15 October, 2012

New Emergency Department at St George Hospital (SSD 5029)

Council has now reviewed the information and provides the following comments:

LANDSCAPE PLAN
SCALE 1:200

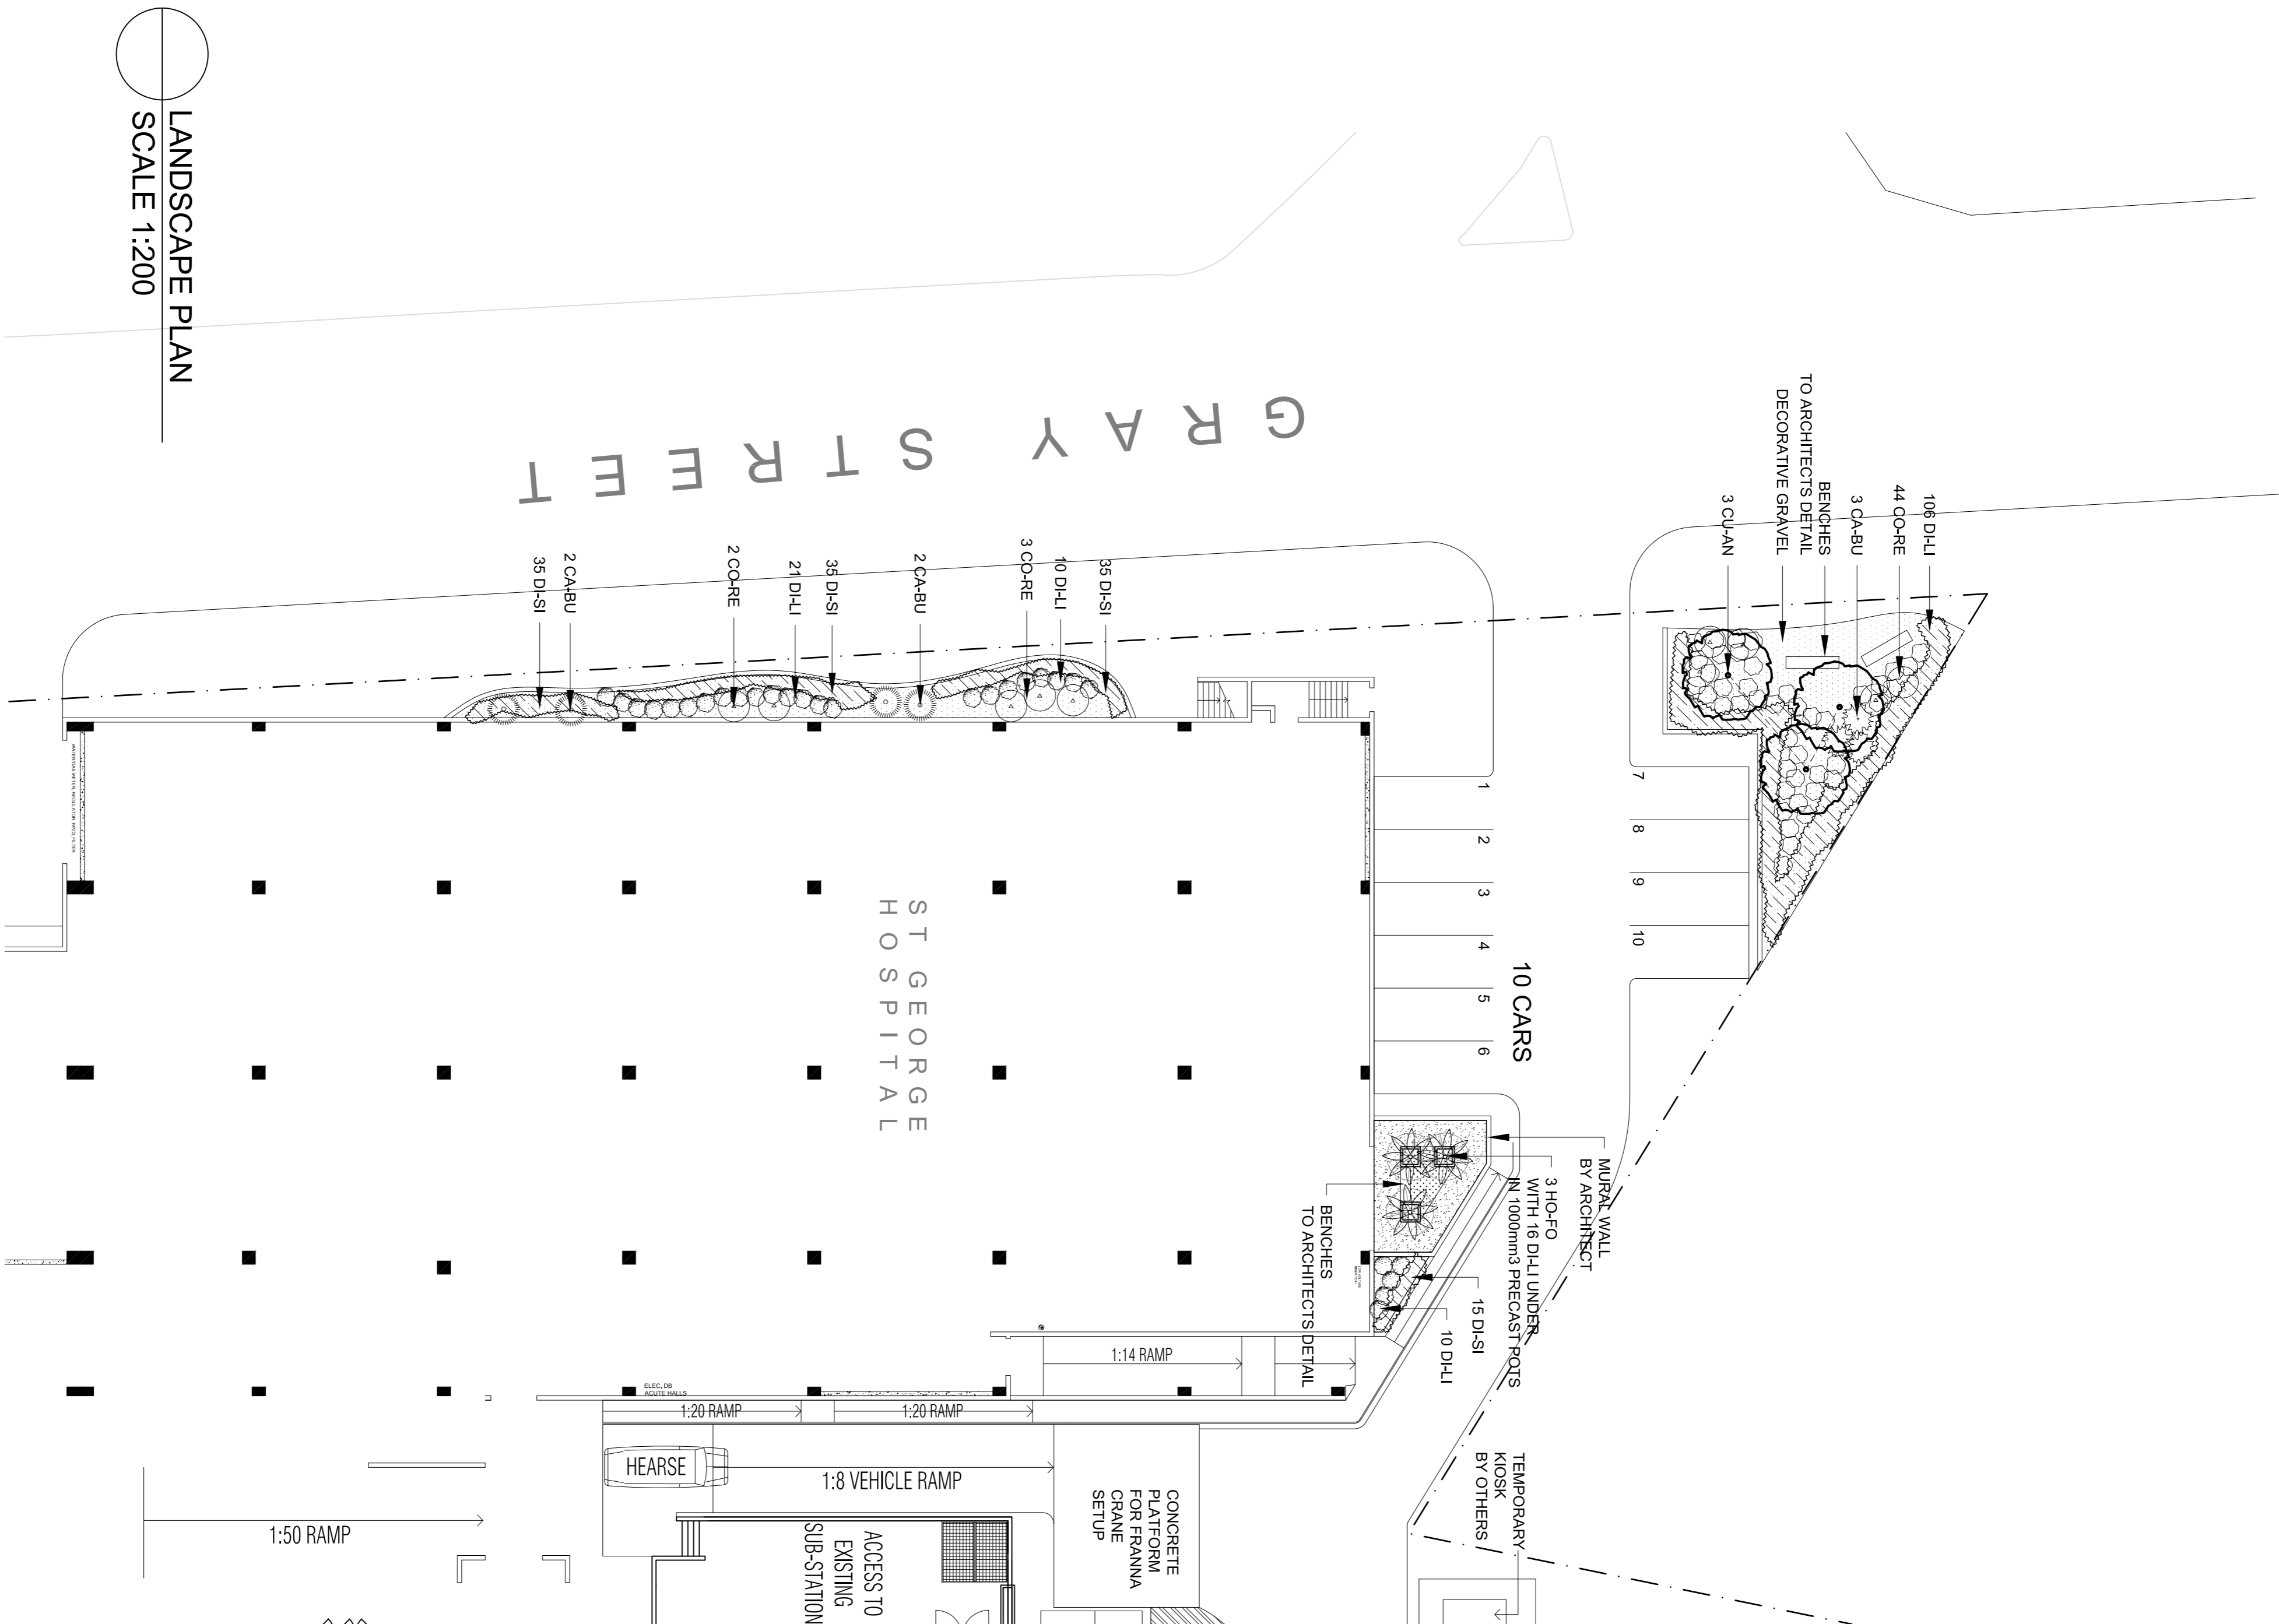
Council's Landscape Officer supports the retention of trees 1, 3 and 12, however considers that the proposed development would need to be redesigned to avoid and minimise impacts from the proposed major encroachment. In this regard, Council is recommending the following draft conditions, as outlined below be included, in addition to the conditions already provided to the Department:

The trees identified for retention in the Arborist Report prepared by *Aboreport – Vegetation Management Consultants* and dated 27 July 2012, including the Trees identified as Tree 1, Tree 3 and Tree 12 shall be protected in accordance with the requirements of Section 4 - *Australian Standard AS 4970-2009 - Protection of trees on development sites* and the recommendations/tree protection notes of the submitted Arborist Report by *Aboreport – Vegetation Management Consultants*

Tree Protection Zone (TPZ) around the trees to be retained are not to have soil level changes or services installed in this area. Any structures proposed to be built in this area of the trees are to utilise pier and beam or cantilevered slab construction.
